The applicant's plans, as contained within submitted document 2020-93954_+Proposed+Site++Block+Layout_957506.PDF seem odd.

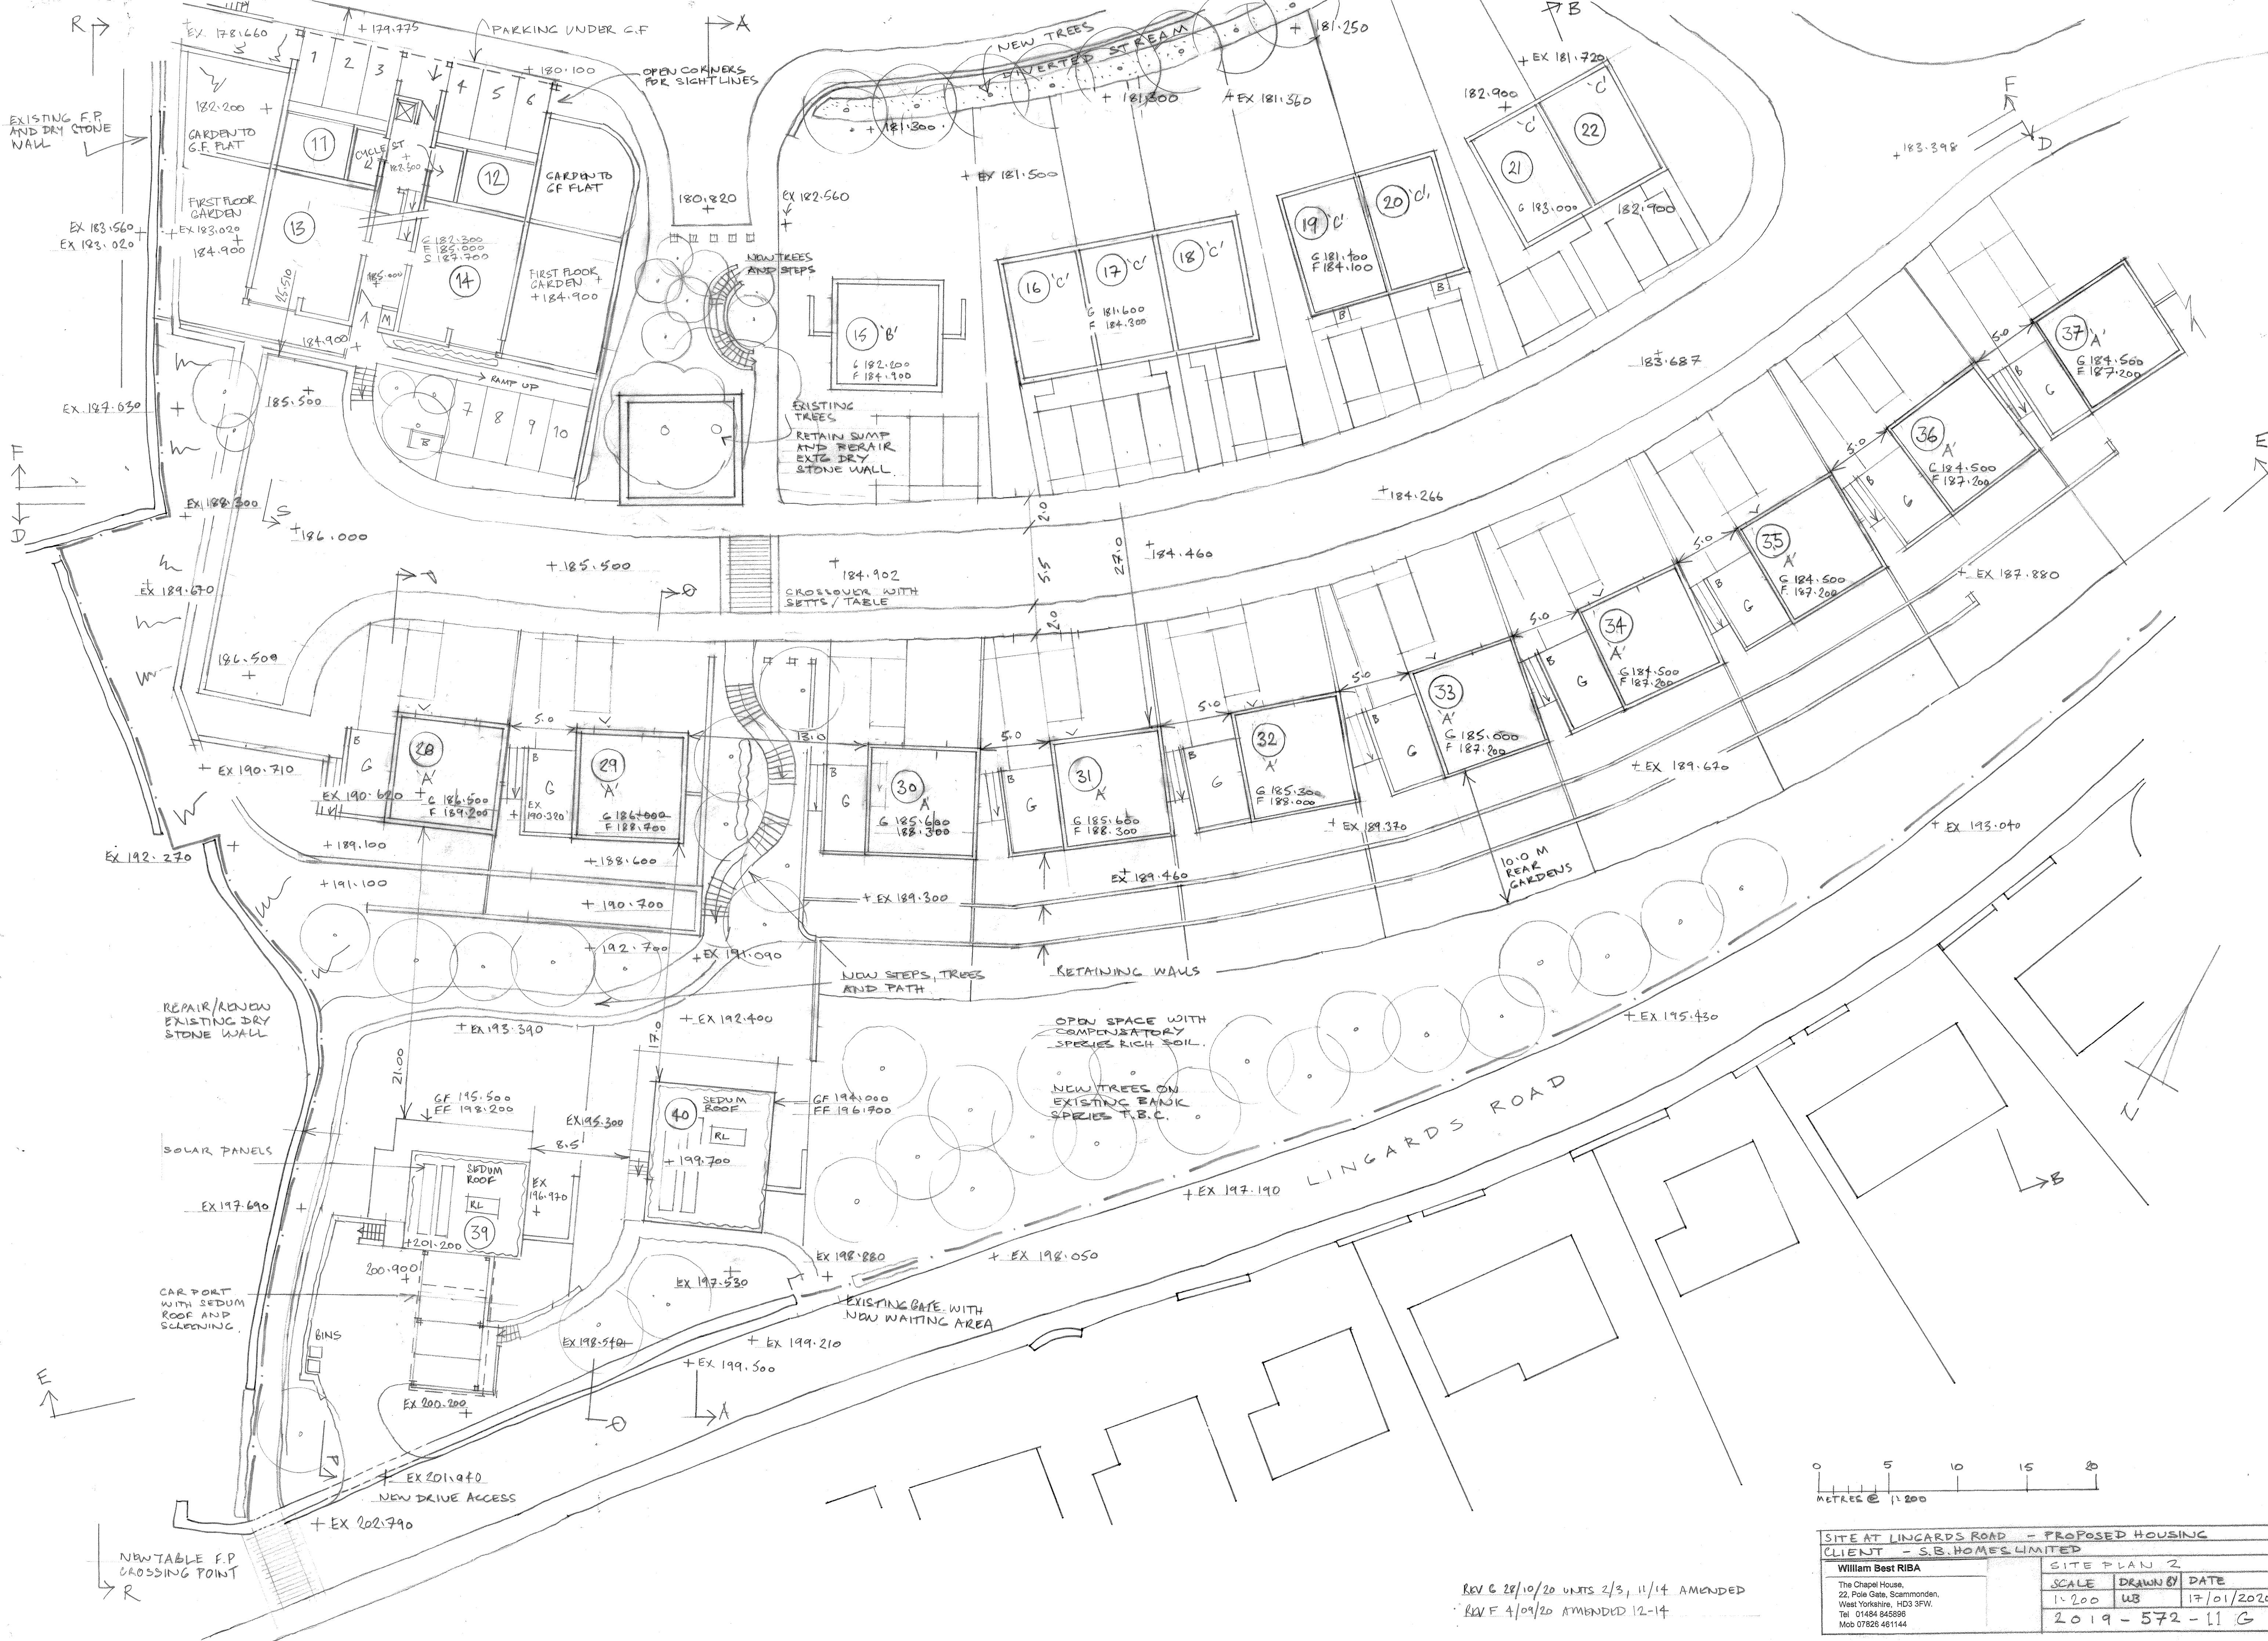
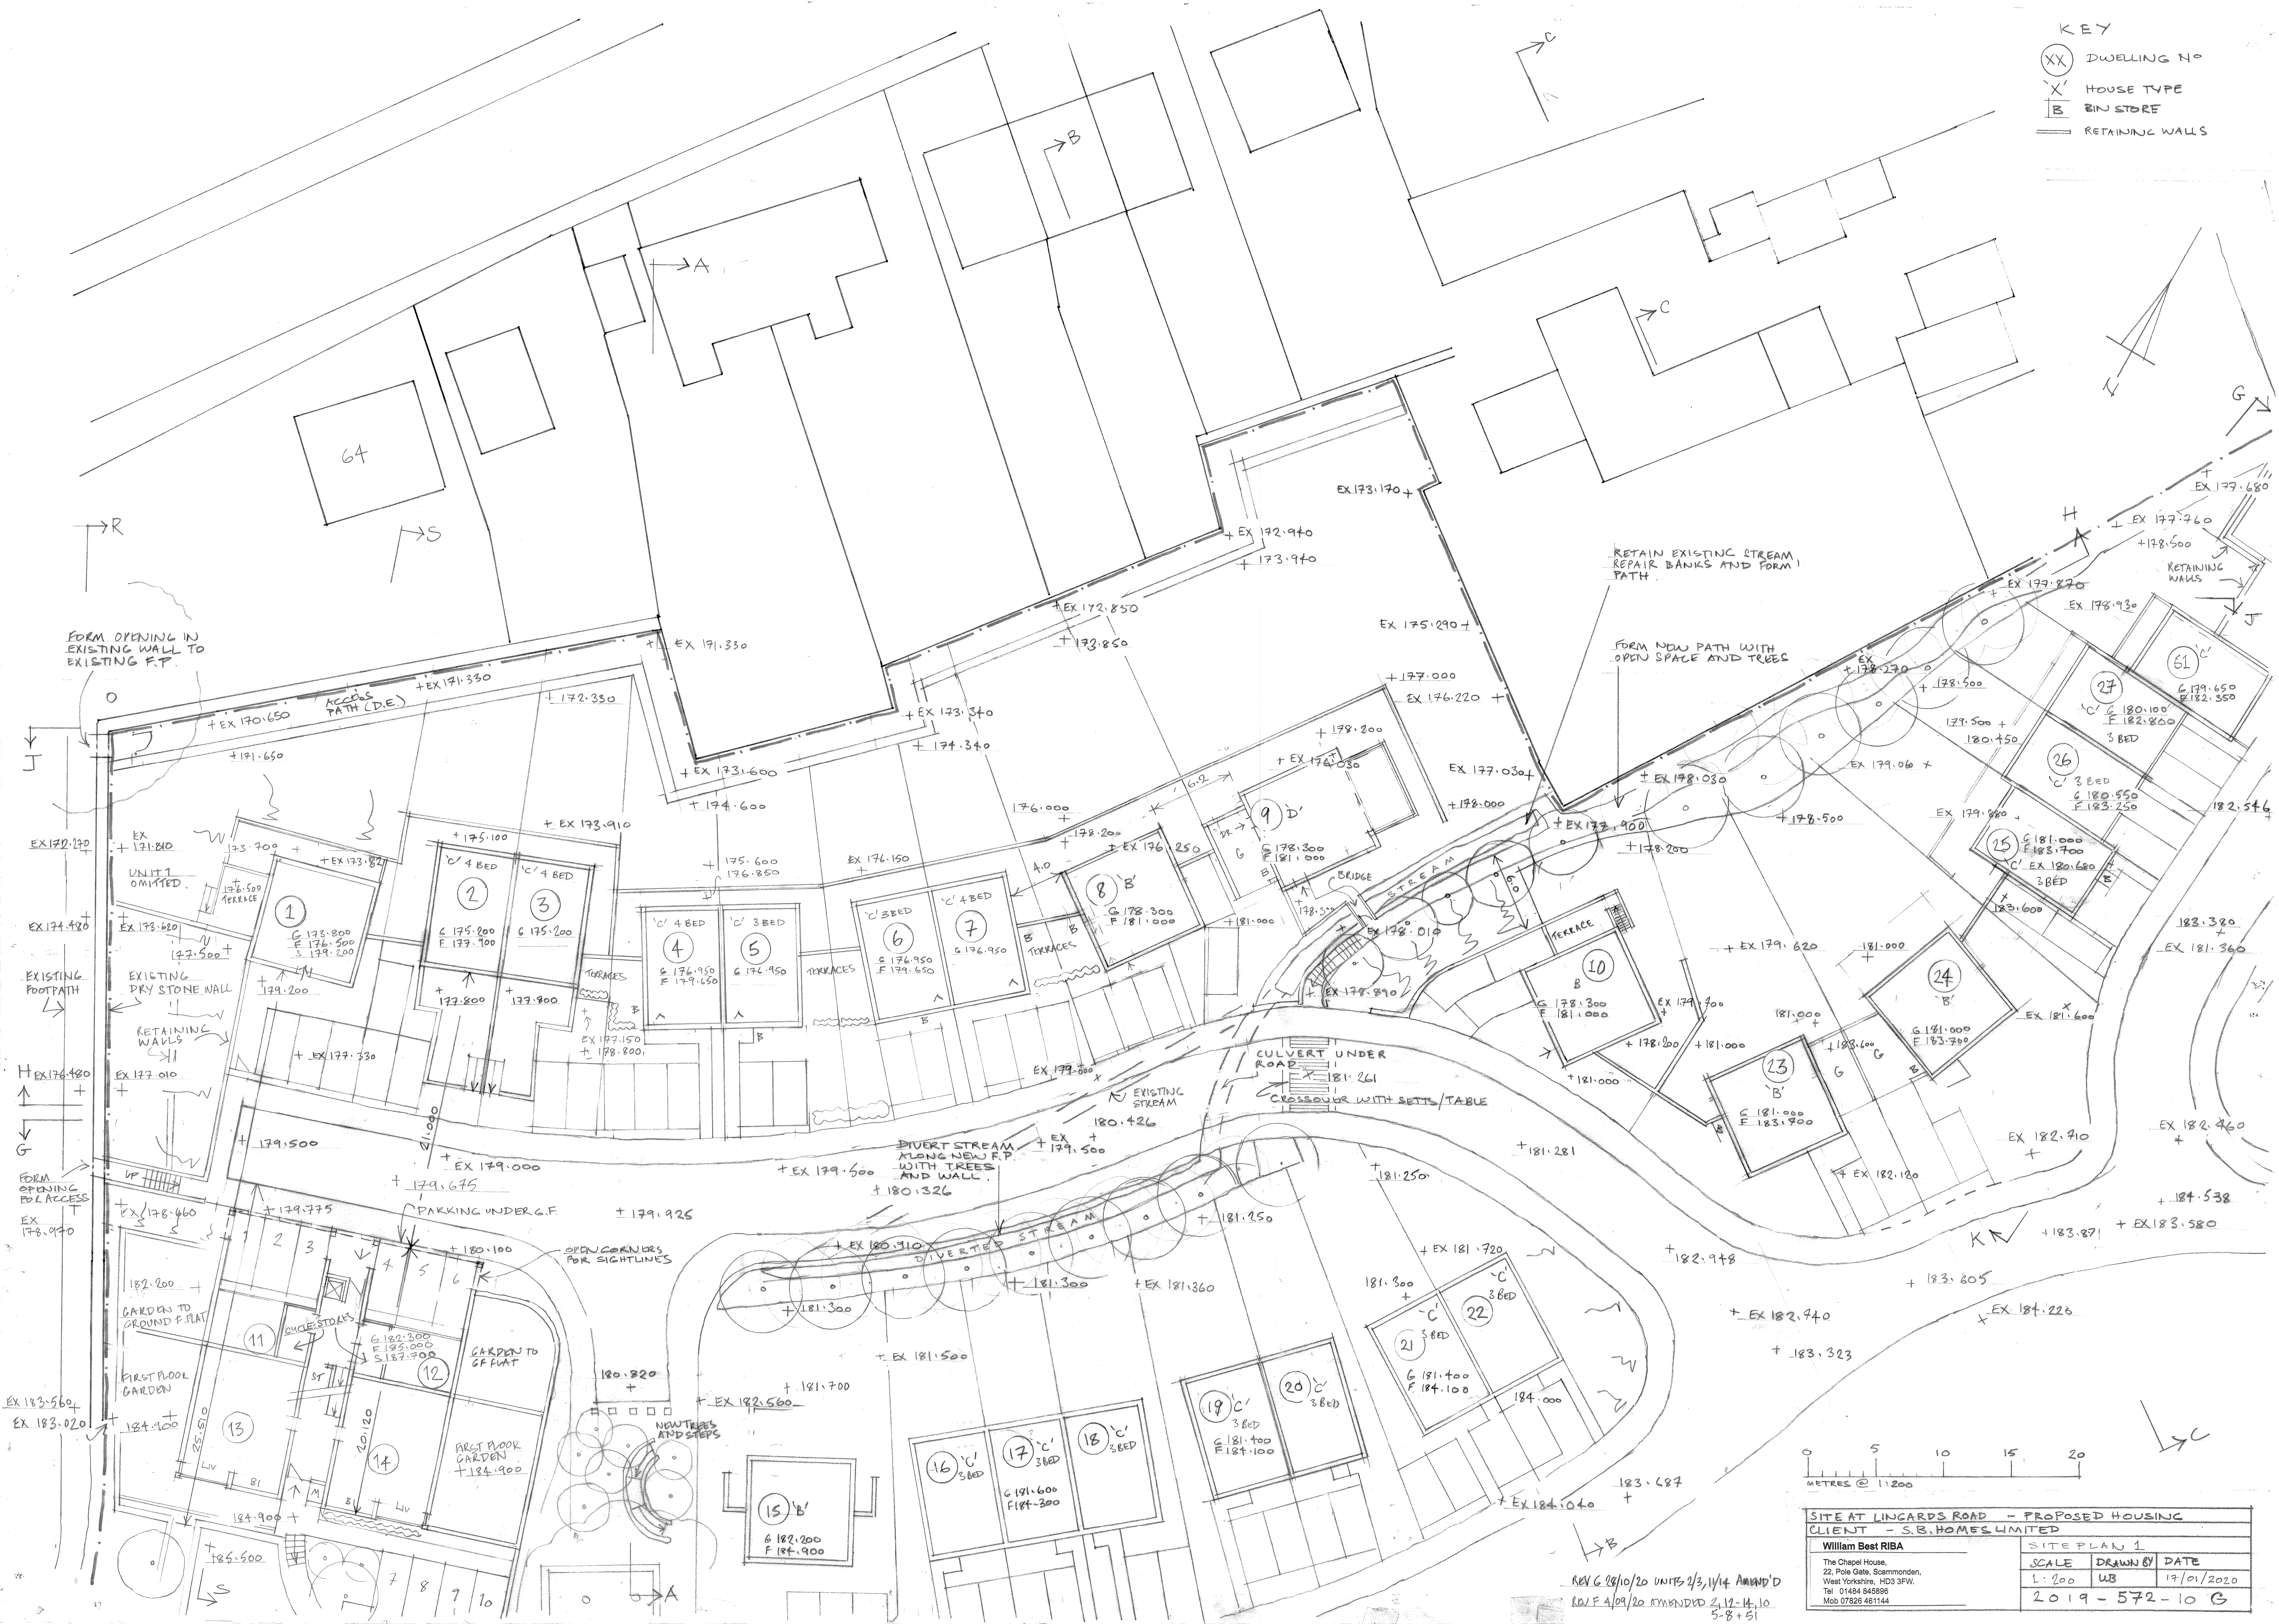
The applicant appears to be proposing a gate post that would be positioned away from the drive, on a footpath: *see yellow arrow below*.

They also appear to be proposing to place a dwelling against Lower Wood Farm: *see image below*.

Neither of these can be classed as good design.
